From: Aldingbourne Parish [REDACTED]
Sent: 14 June 2019 21:50
To: Nicola Spencer
Cc: Planning.Responses; Planning
Subject: Objection re Applications AL/42/19/PL and AL/43/19/L

AL/42/19/PL AND AL/43/19/L

Pigmento Red Zinc

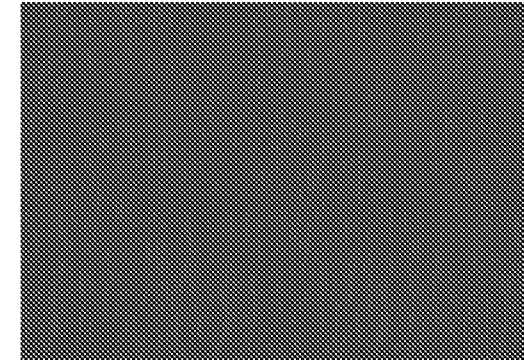
proposal to be set next to 'character' and 'listed' buildings - this council feels the proposed red zinc material is particularly out of character,

Traditional Flint Wall

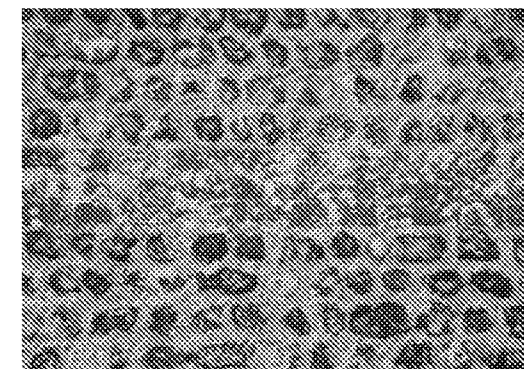
3) EH11 - this policy seeks to protect flint walls within the Parish. This current planning proposal will however obliterate the view of the existing 3m high flint wall; and the proposed modern construction (which will be sited very close to that wall) fails to sympathetically reflect the flint character.
